From: Laura Gibbons <Laura.Gibbons@arun.gov.uk>
Sent: 13 May 2019 16:33
To: Planning.Responses <Planning.Responses@arun.gov.uk>
Cc: Simon Davis <Simon.Davis@arun.gov.uk>
Subject: RE: Planning Consultation on BR/126/19/DOC

Engineers Comments Regarding Condition 3- surface water drainage

Site Address: 65C Gravits Lane Bognor Regis PO21 5LN

Description of Works: Approval of matters reserved by condition imposed under BR/208/14/PL relating to condition 3-surface water drainage.

LOCATION PLAN
65C GRAVITS LANE BOGNOR REGIS

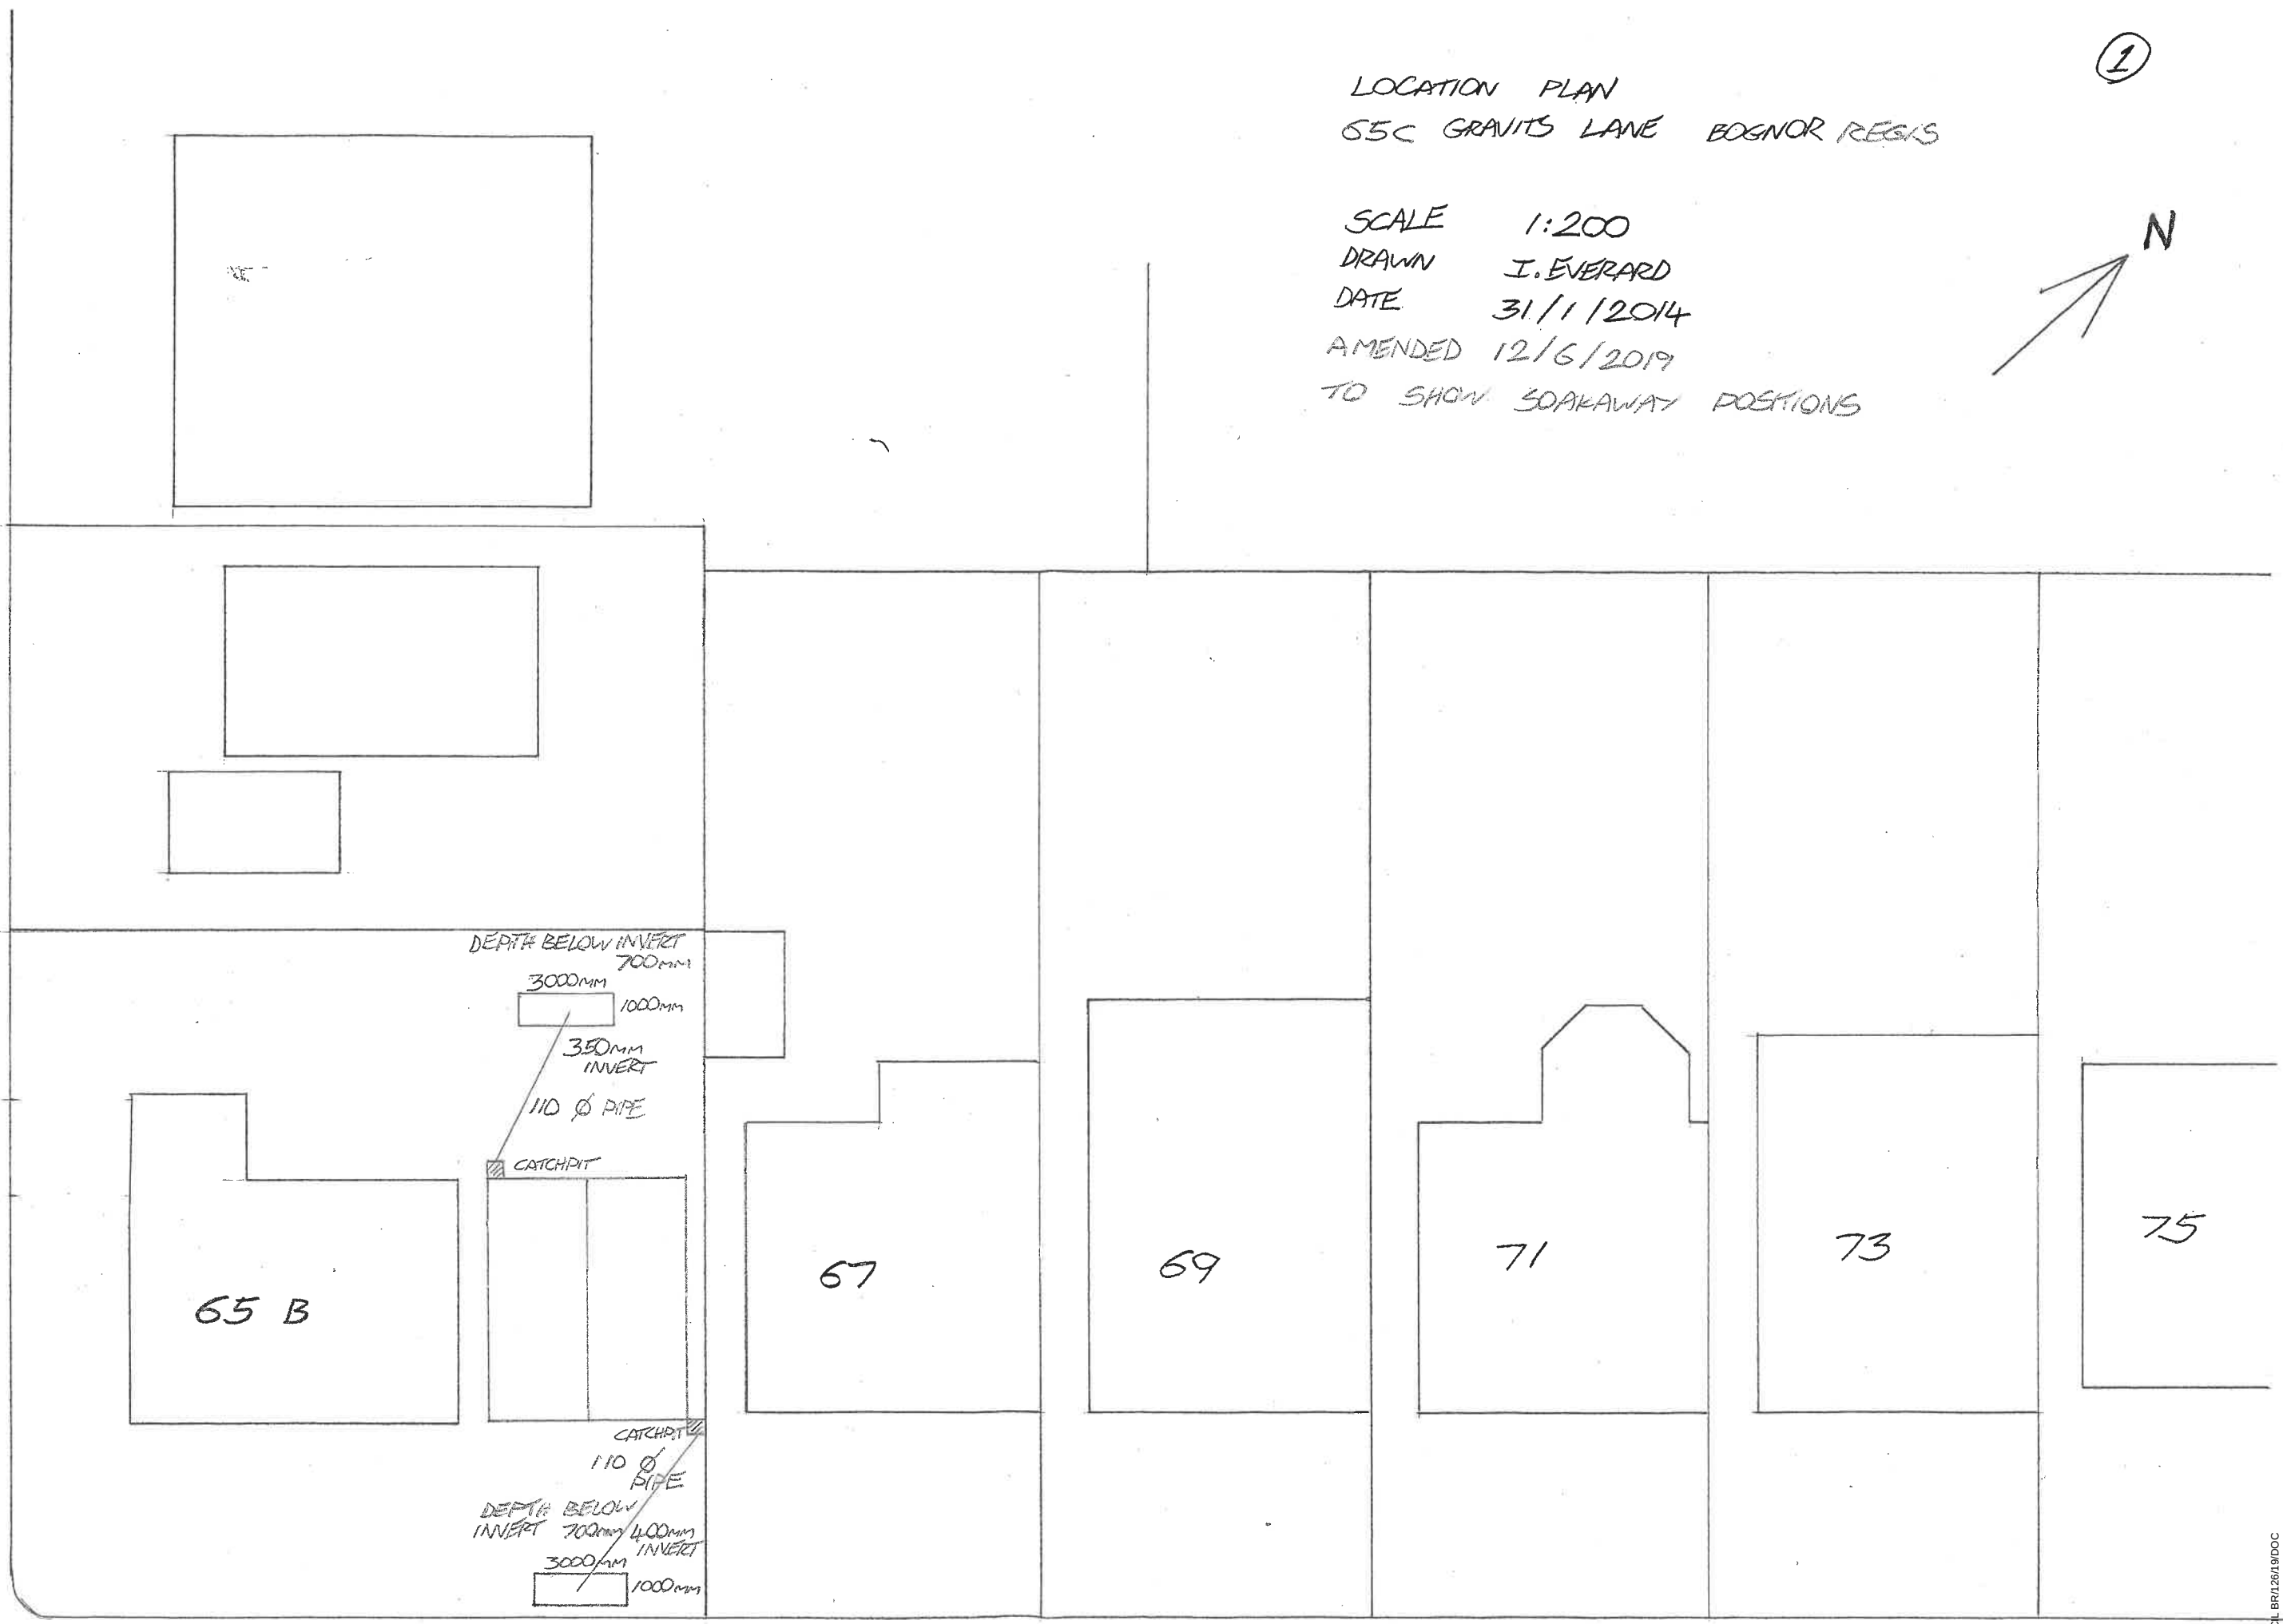
1. Insufficient storm durations have been detailed within calculations. Storm durations between 5 minutes and 24 hours should be examined.
2. Please can the applicant confirm when infiltration testing was completed, and to what depth.
3. Construction detail drawings are required.
4. Layout drawings need to be provided to scale and detailing proposed soakaway dimensions including invert and cover levels.
5. Catchpits need to be shown on plan upstream of all connections to soakaways.
